From: Martyn White
Sent: 19 June 2019 17:11
To: Anita Gardner
Subject: RE: AB/32/19/L - 13 Mount Pleasant Arundel BN18 9BD

From: Peter Davey [REDACTED]
Sent: 16 May 2019 12:22
To: Anita Gardner
Subject: AB/32/19/L - 13 Mount Pleasant Arundel BN18 9BD

client	project	drawing	date	drawn	drawing no	revision
Christine Fowler	New Doors / Windows at Dove Cottage, 13 Mount Pleasant Arundel, BN18 9BD	Proposed floor plan + elevations	Dec 18	pd	0273 / 102	A
			scale	CAD file name:		
			1:100, 1:200 @ A3

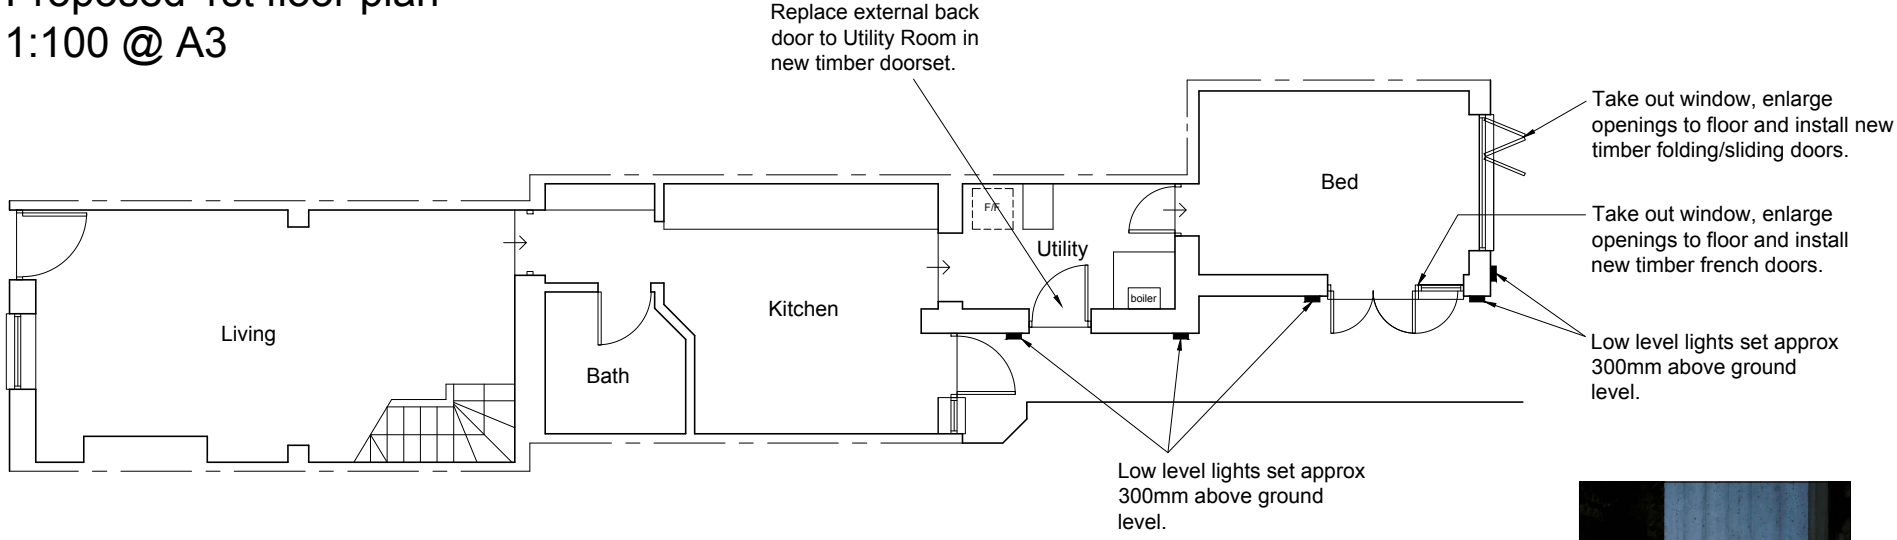
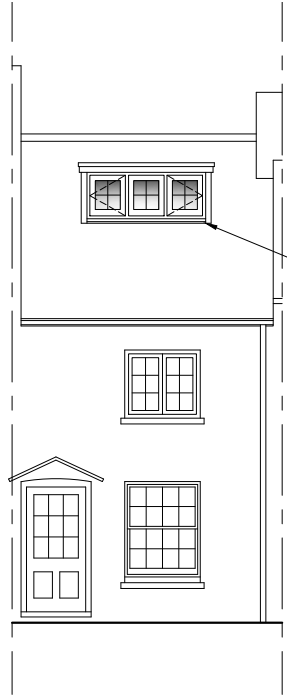
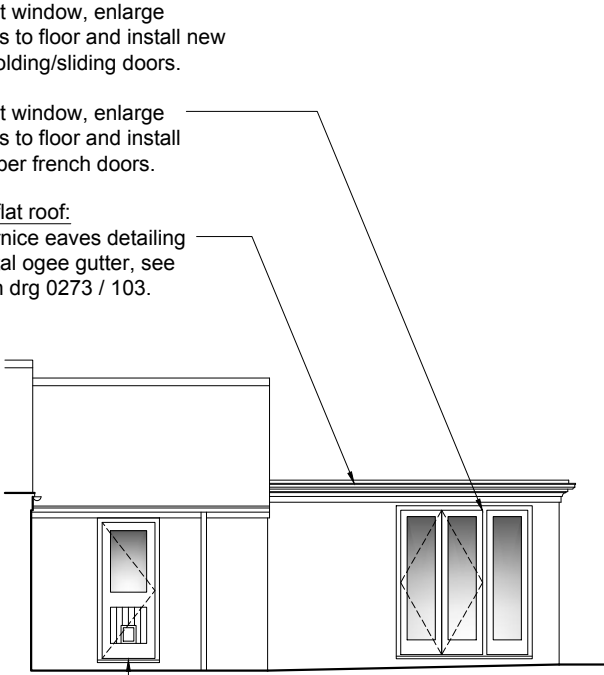
I note that two options have been provided for the low level lighting – please can it be confirmed which is proposed to be used?”

The alternative projecting light fitting has been omitted in favour of the original flush brick design.

Typical horz Section thro
New 2nd floor Window
1:5 @ A3

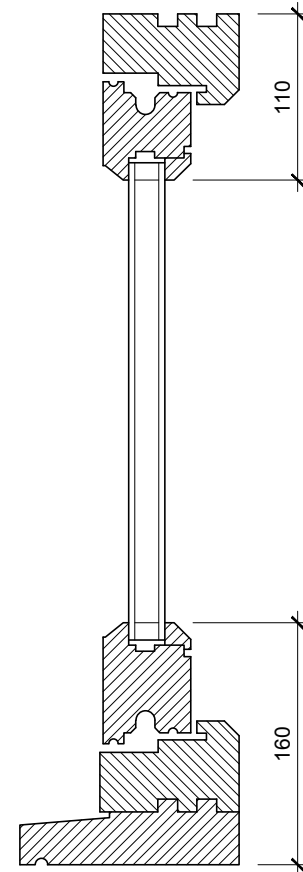
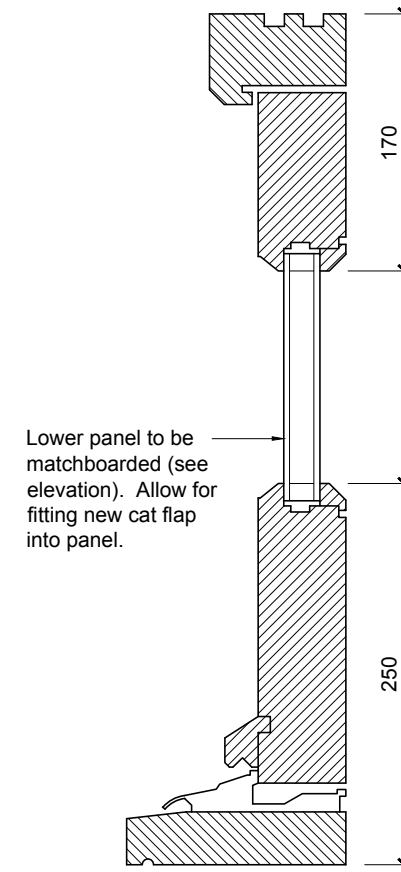
The standard approach with regards to double glazing is to only support the use of the new slim-profile double-glazed replacement units in such cases as this. This is in accordance with the relevant Historic England Guidance. The standard windows proposed in this instance cannot be supported from a Historic Environment perspective.

Further to my earlier e-mail I have now received the written comments of the Conservation Officer who has stated "it is not clear how the proposed glazing bars will appear? Will they be integral to the frame or merely placed on the glazing? Further, I note that the proposal is to use double glazed units. Whilst there might be justification for doing

this as the loss of the critical windows is an improvement, it is not clear if the units will be of a standard design or the heritage equivalent. By this I mean the slimmer units. Further, no details are provided regarding the glazing bar for the windows; they should be integral to the frames and not merely added as though an afterthought. These details can be provided for by way of condition if minded to approve the application. the colour of the joinery should also match the existing.

The double glazed units are 24mm thick. The casement stile is 58mm thick, which means the glass is set back 17mm from both faces to ensure the appearance of a traditional casement.

The glazing bars are shaped in timber to match the beading. They protrude both sides of the glass with a spacer within the sealed unit to make them indistinguishable from structural bars. If structural glazing bars had been used, it would significantly reduce thermal performance. Also by using double glazed sealed units, a structural glazing bar would have to be much heavier in profile which would not be in keeping. This proposal allows the use of slimline bars to match the original.
